EPC STORMWATER REVIEW COMMENTS
IN ORANGE BOXES WITH BLACK TEXT

Early Grading Permit - Final Drainage Report

Overlook at Homestead Subdivision Filing No. 1 El Paso County, Colorado

**Kimley»Horn**  
 OVERLOOK FILING NO. 1  
 EL PASO COUNTY, COLORADO  
 PRELIMINARY DESIGN PLANS  
 EXISTING DRAINAGE MAP

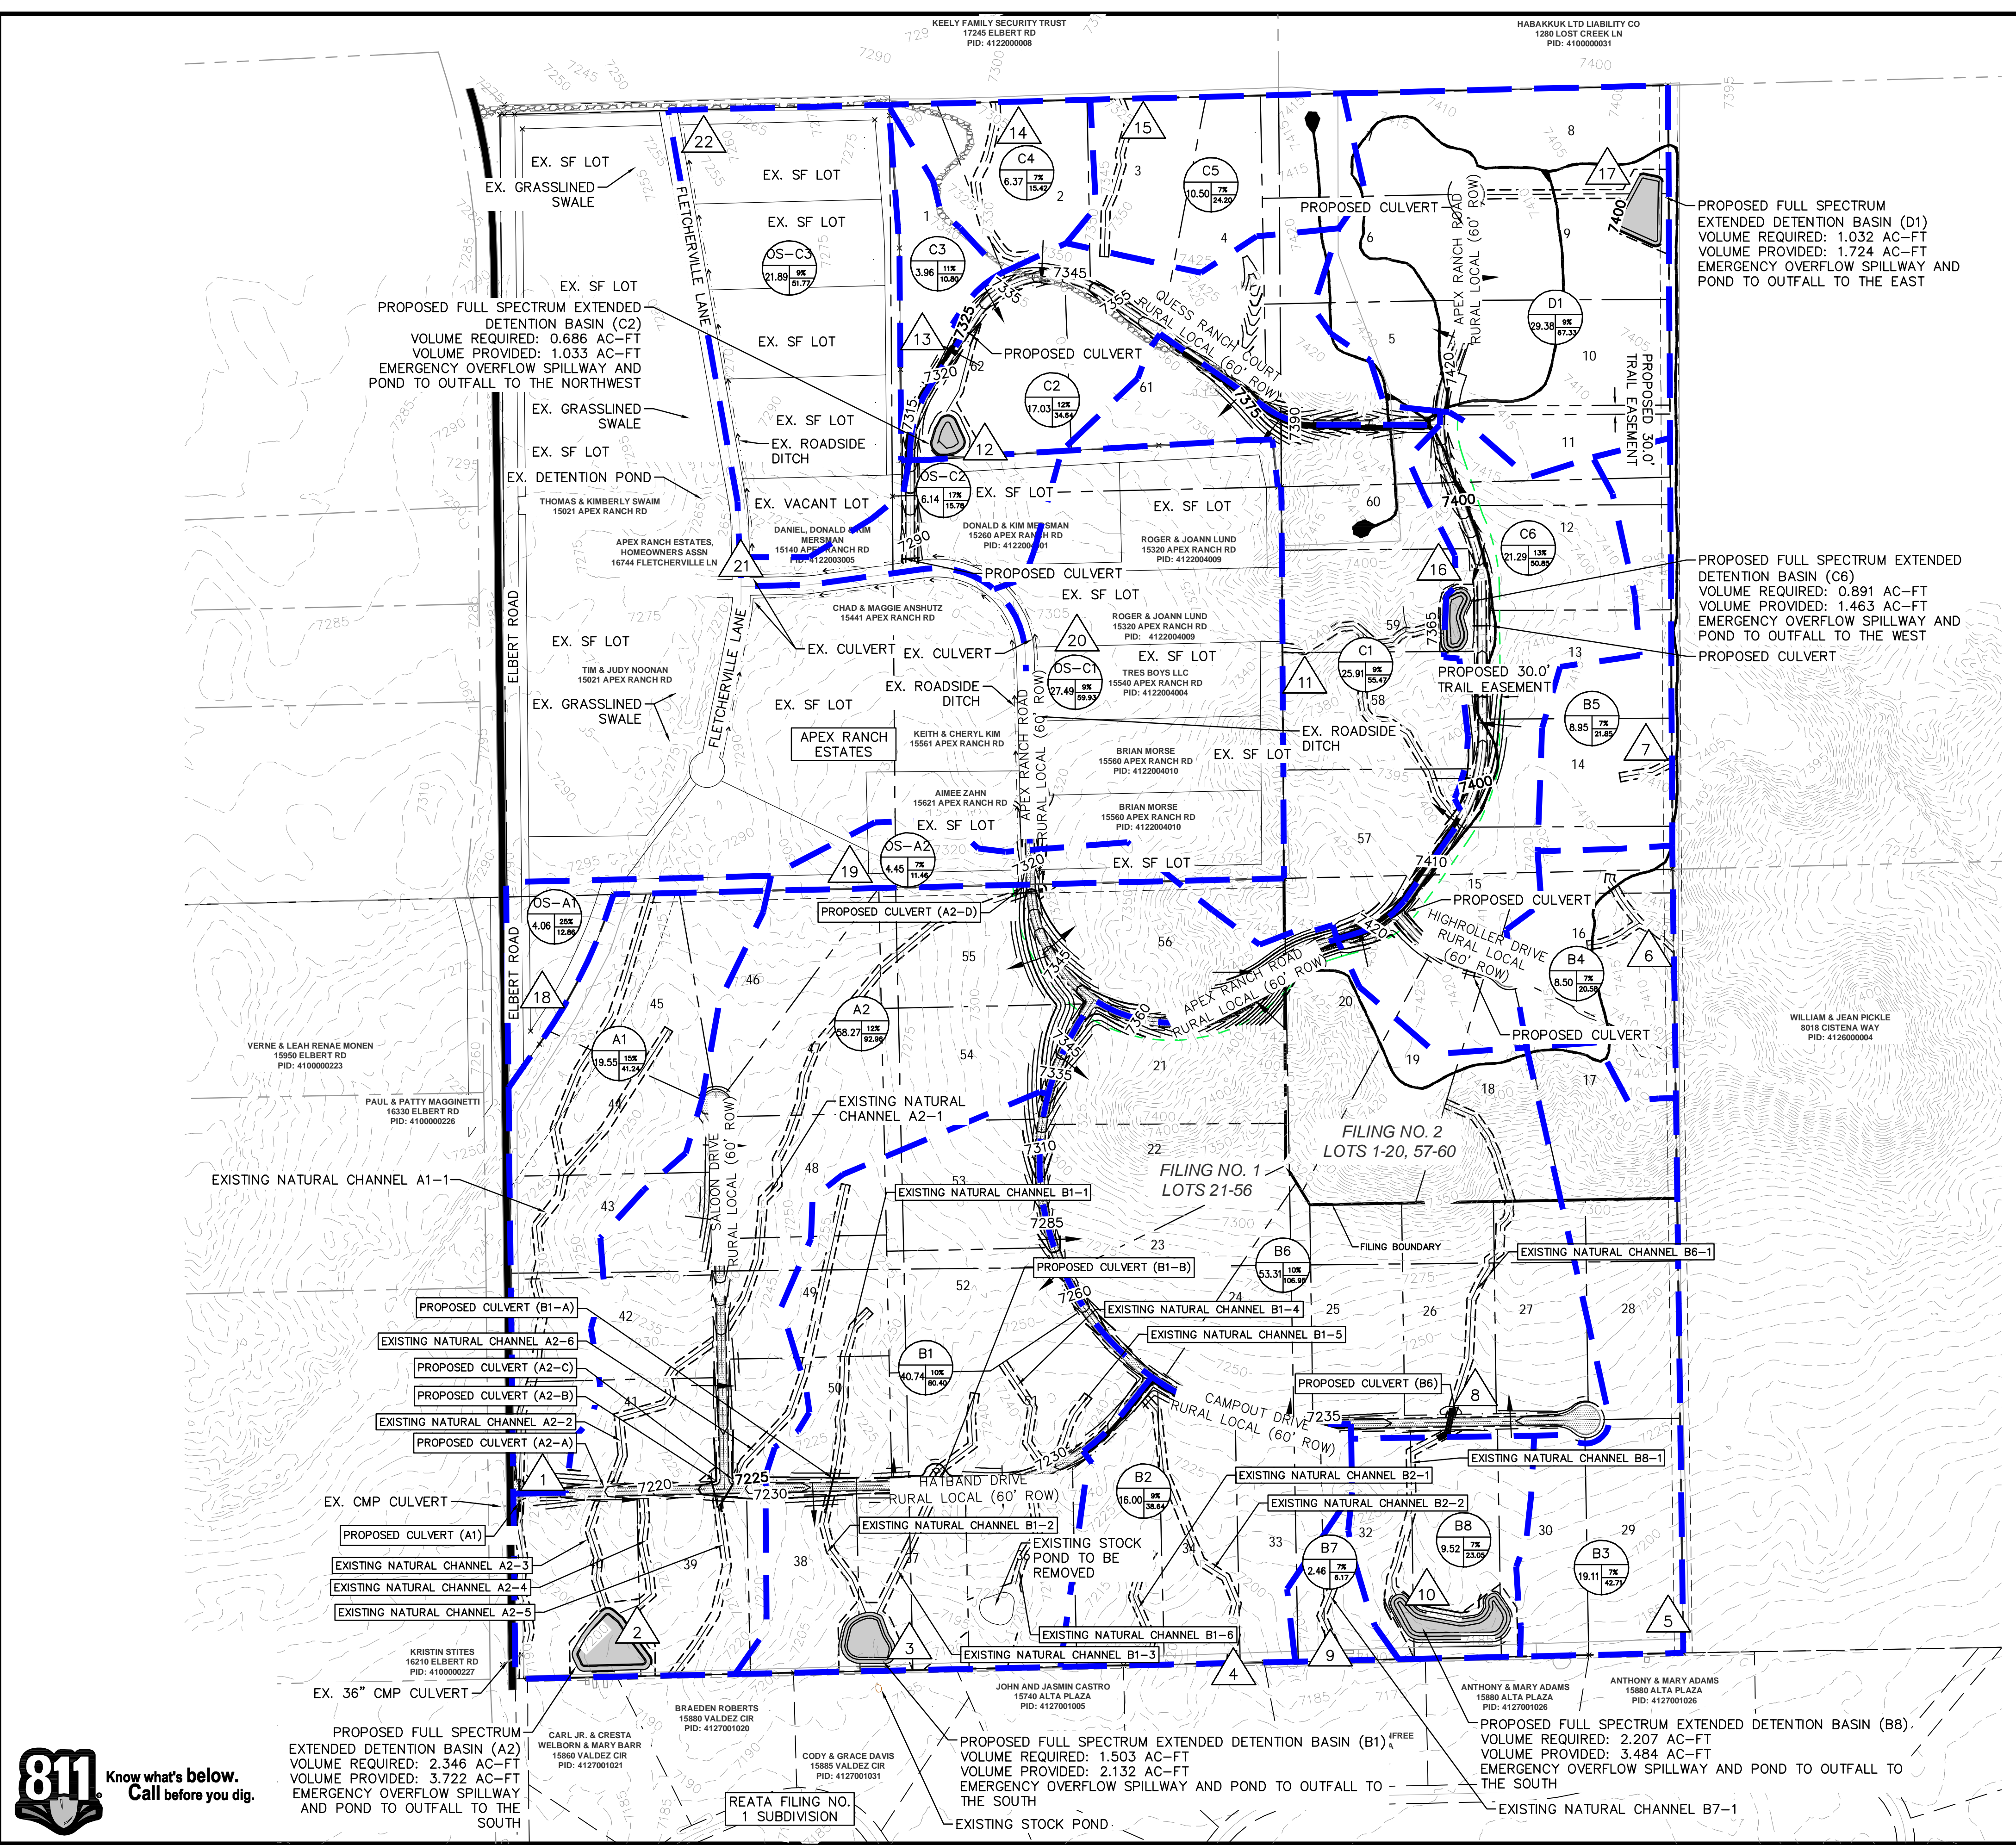
Please include B2

Please provide a brief discussion of how the existing runoff flow interacts with the existing natural channels shown on the proposed drainage map.

Hydraulic analysis of channels has been added to appendix. Discussion added including reference to appendix. Channels now shown on existing drainage map.

PROJECT NO.  
196239003  
SHEET  
**EX-2**

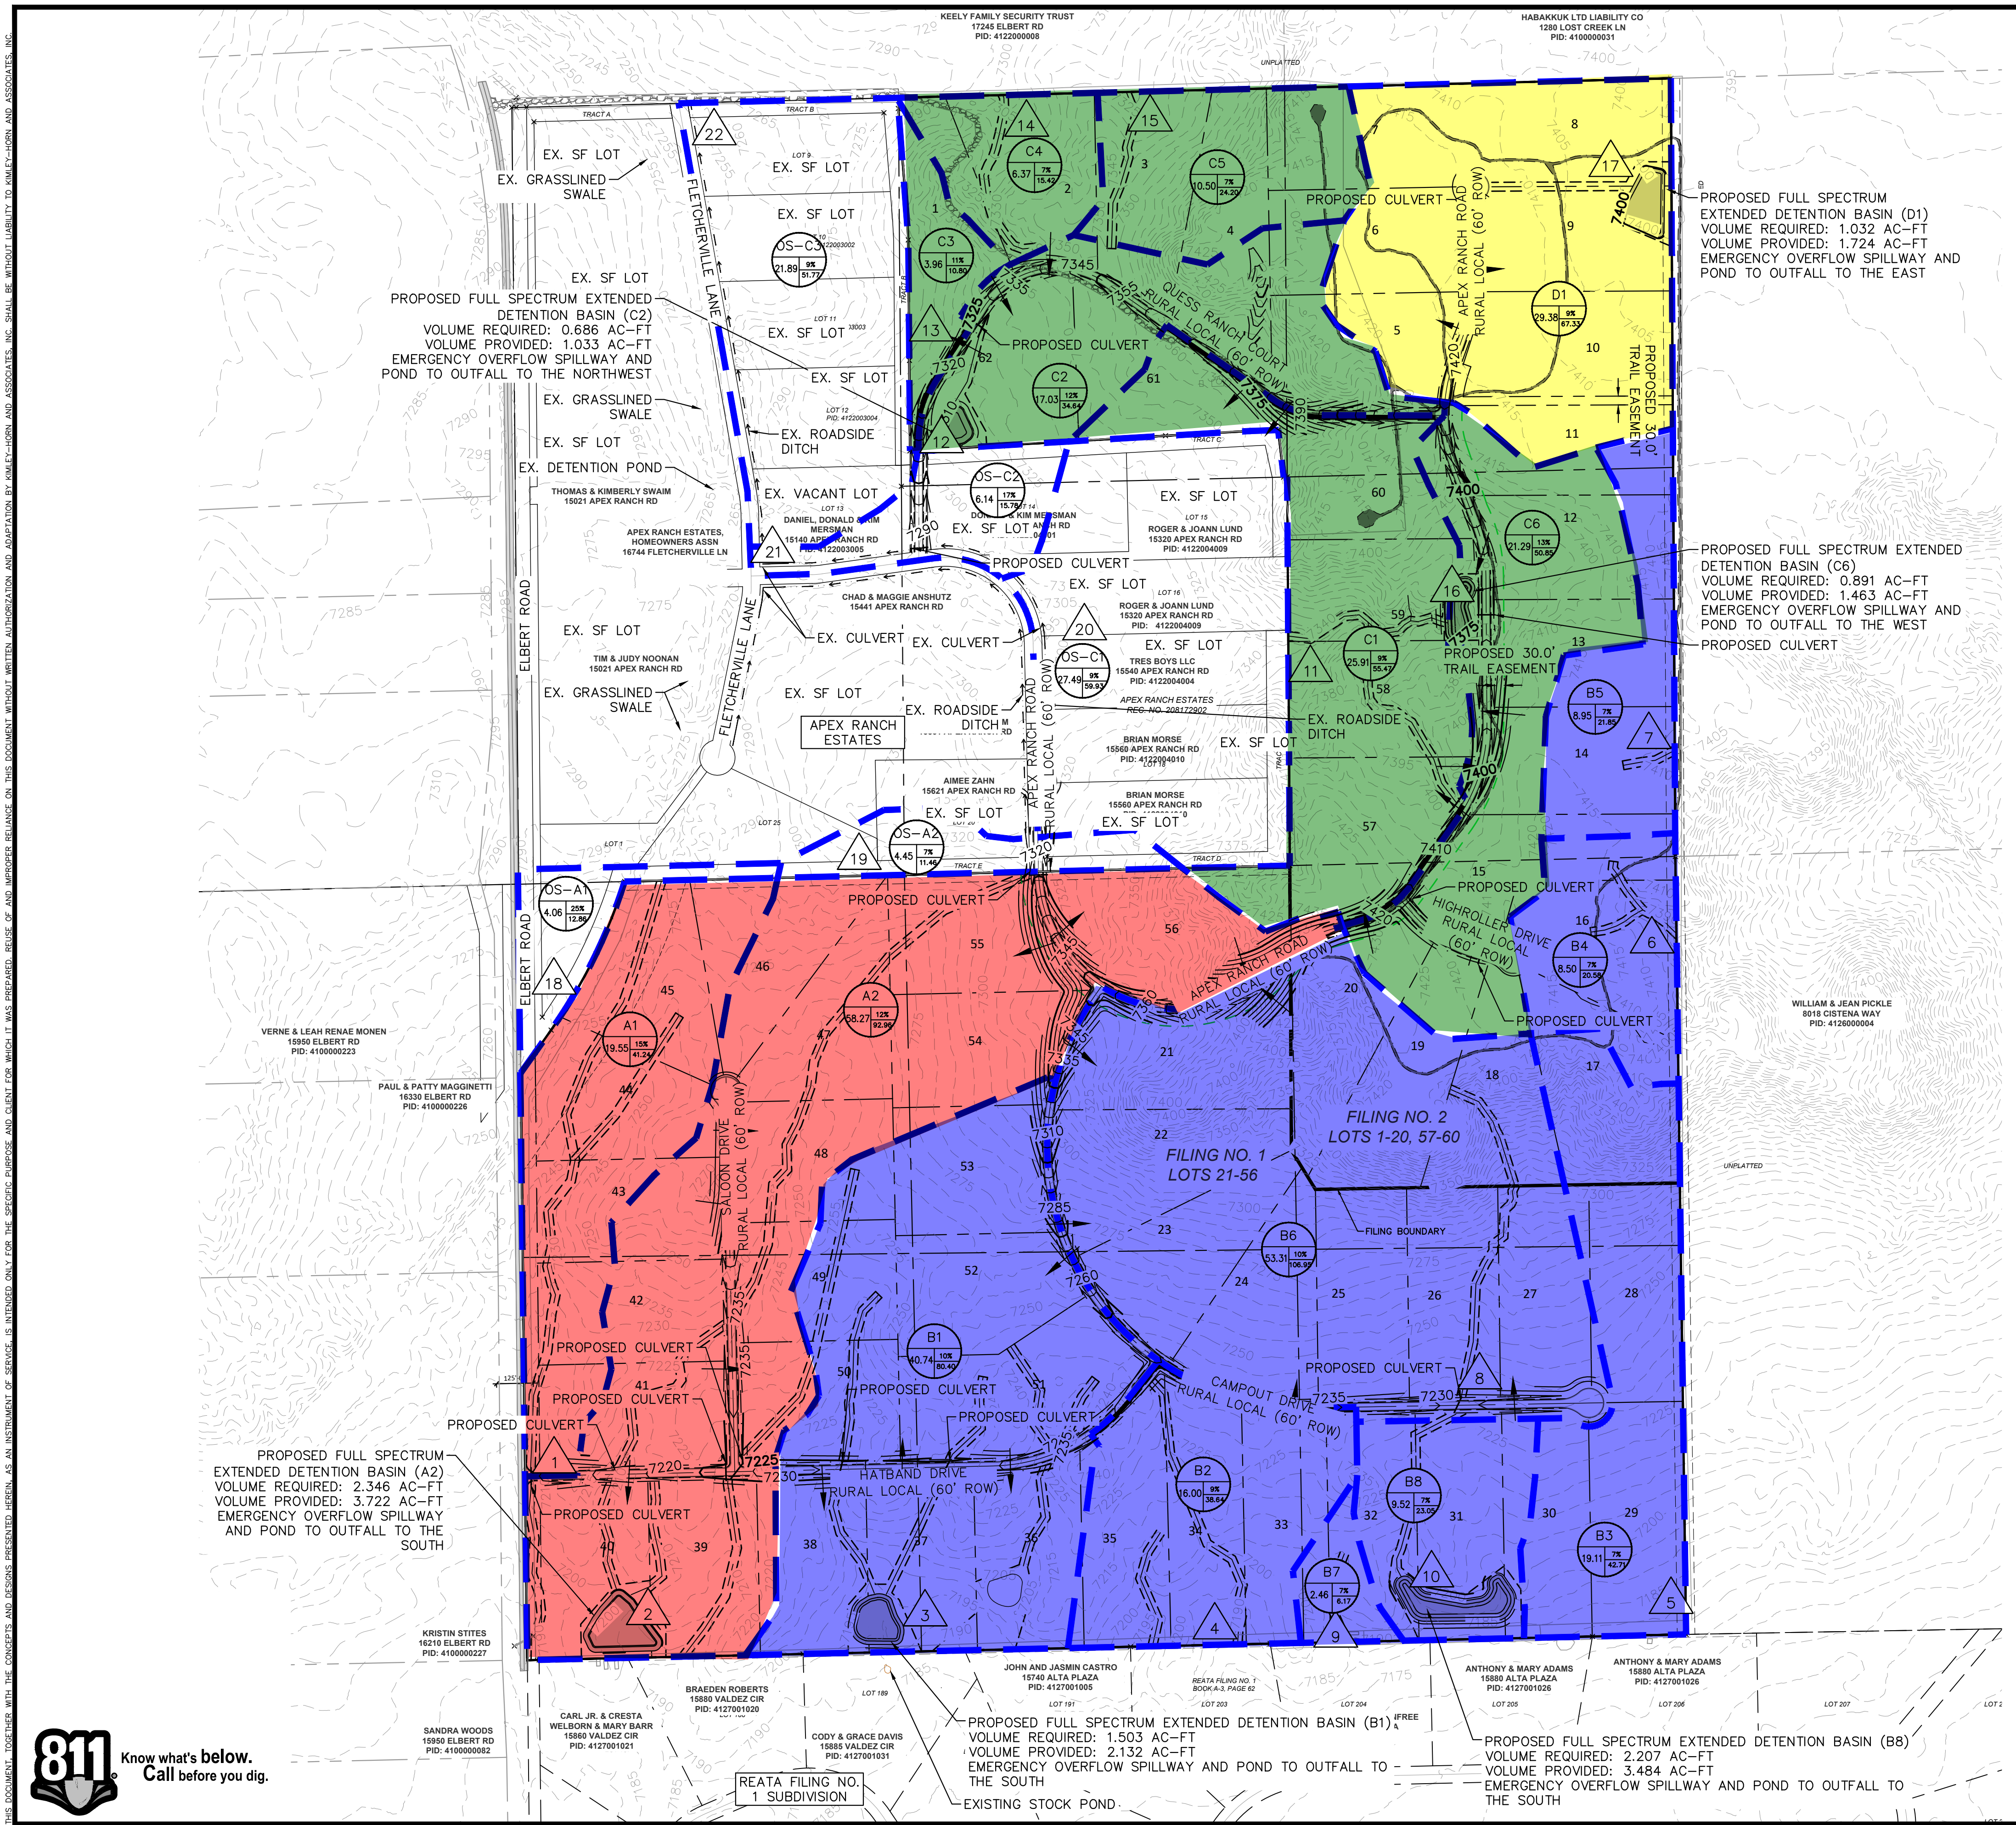
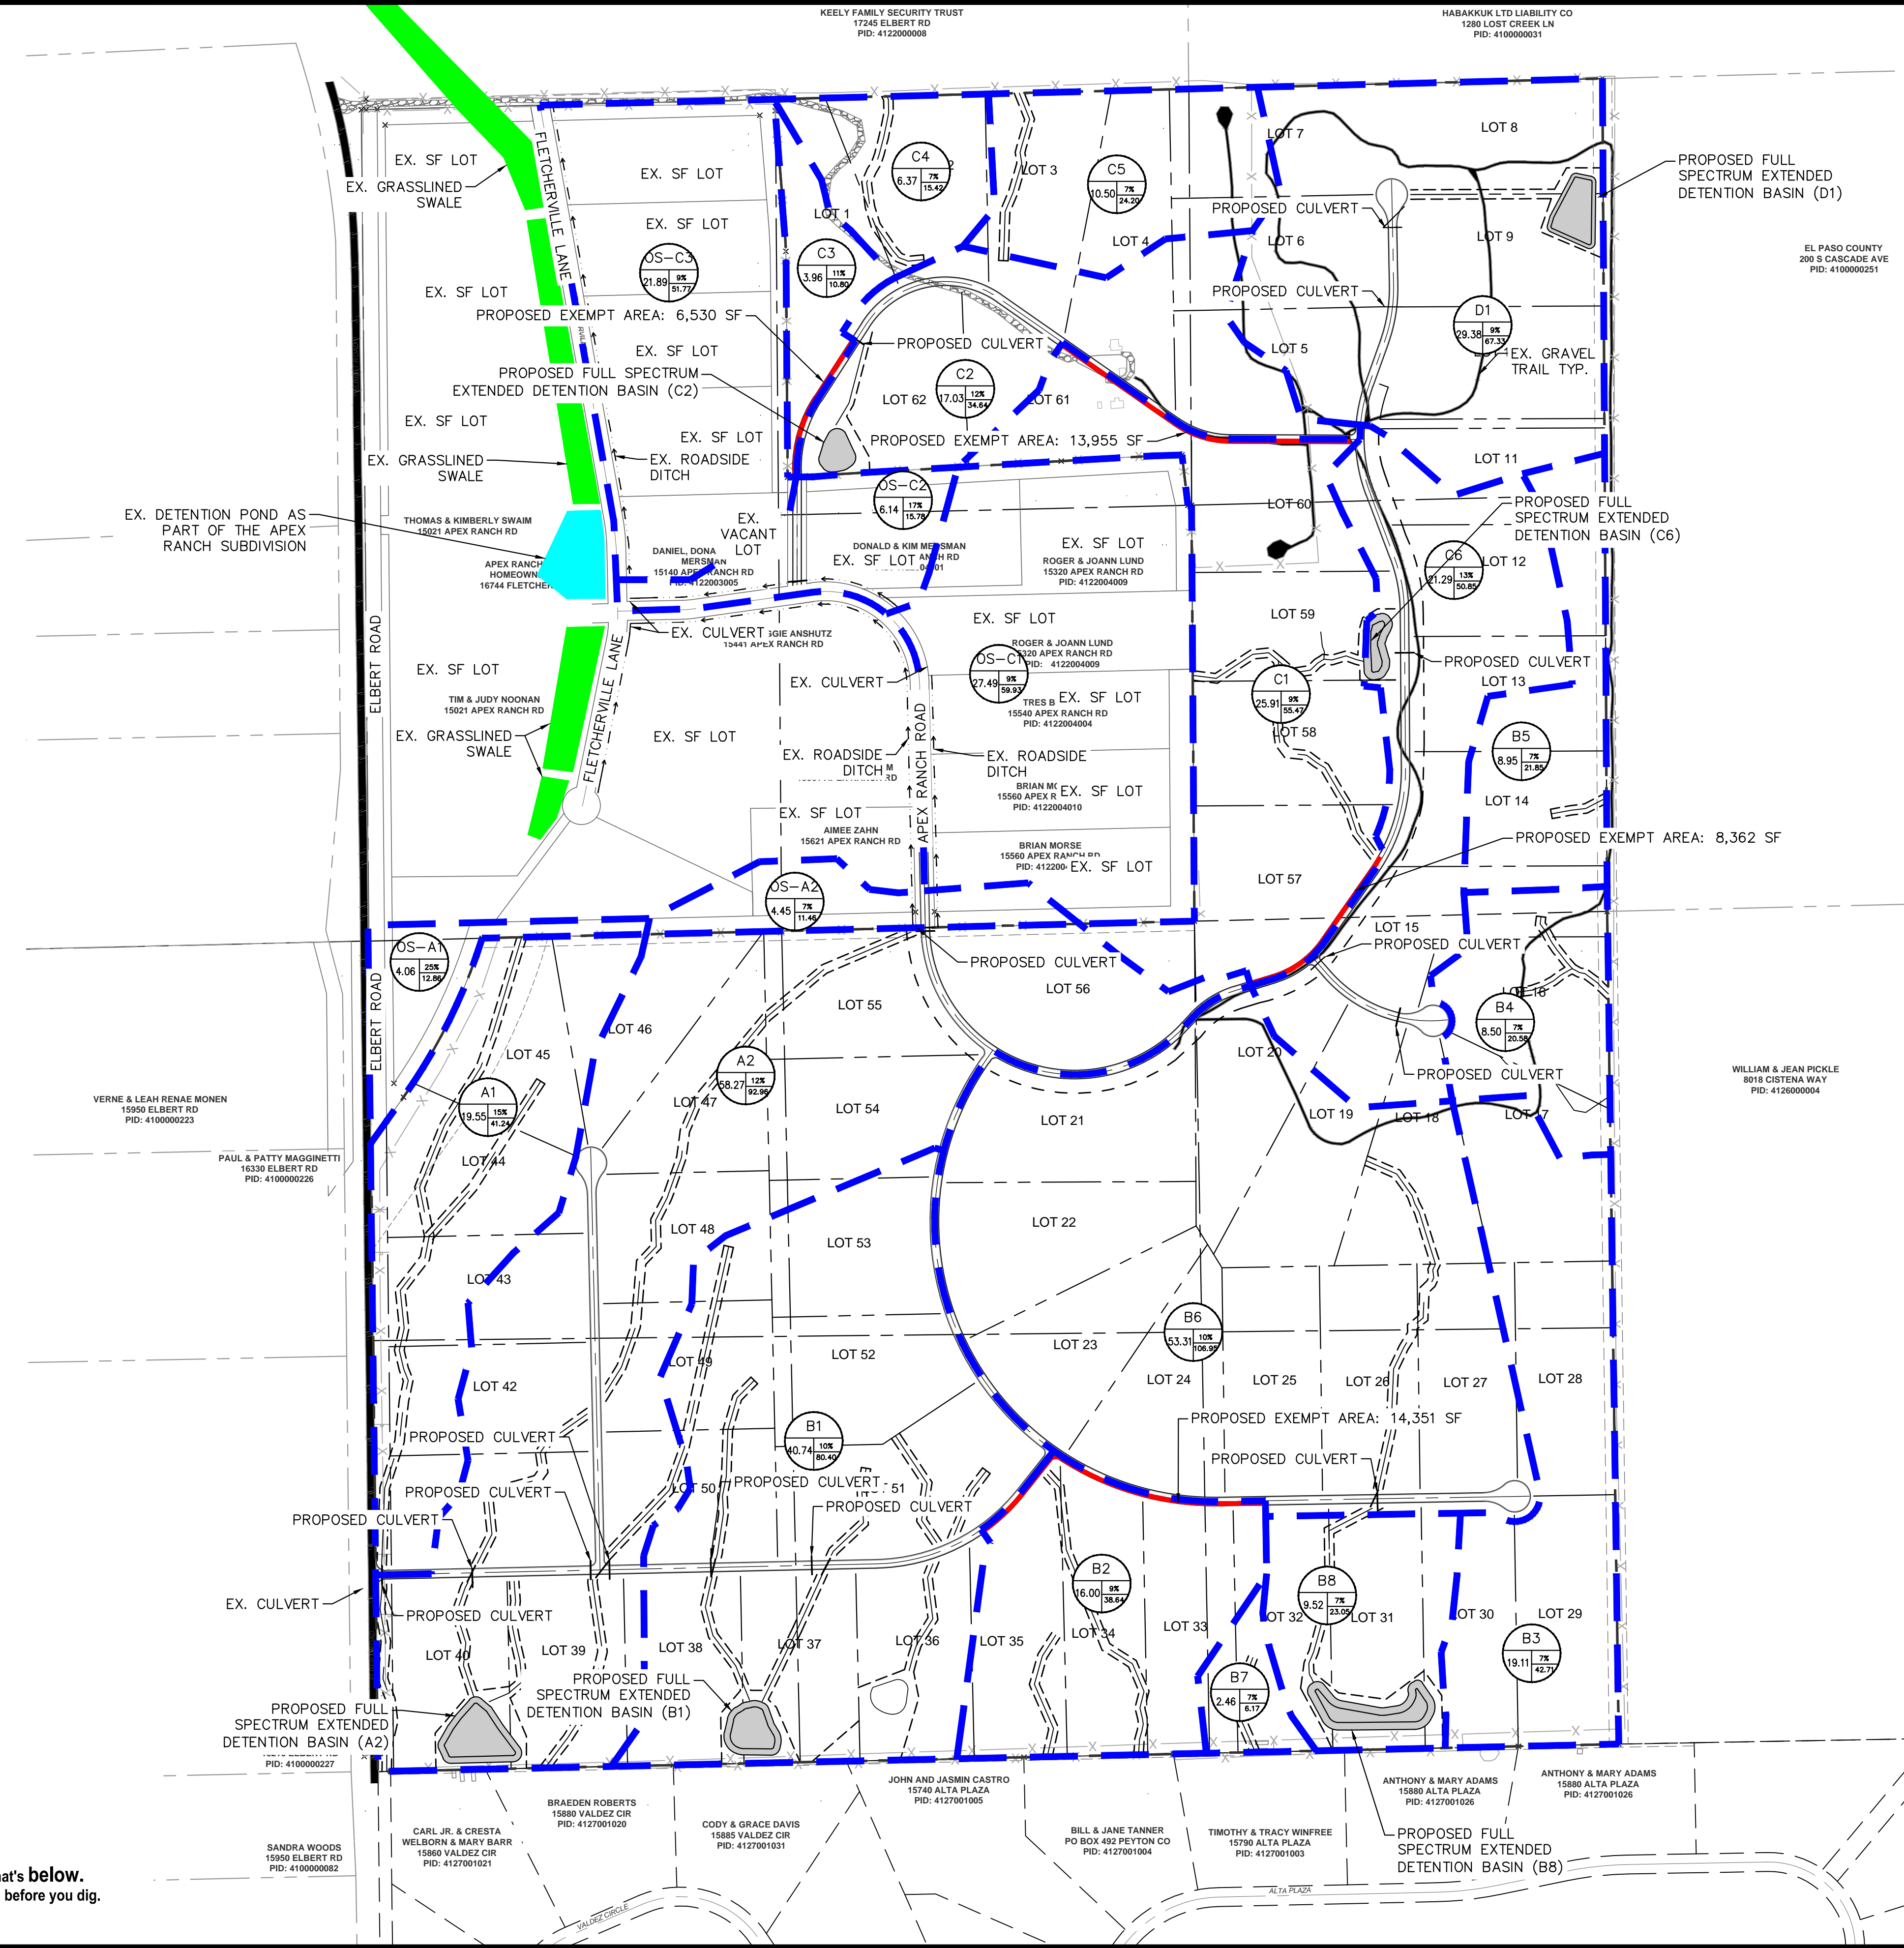
Please provide a brief discussion of how the proposed runoff flow interacts with the existing natural channels shown on the proposed drainage map. Note that if the proposed storm water flows are increased, please explain how these channels can handle the proposed flows.

As there is no development occurring within this basin, the impervious % should be the same as existing. It appears that each of these basins is taking into account the future development to occur on site but only the rough grading should be accounted for at this stage. Update the drainage plan also.

Discussion regarding channels and erosion protection has been added to report. TRM now called out on channel analysis.
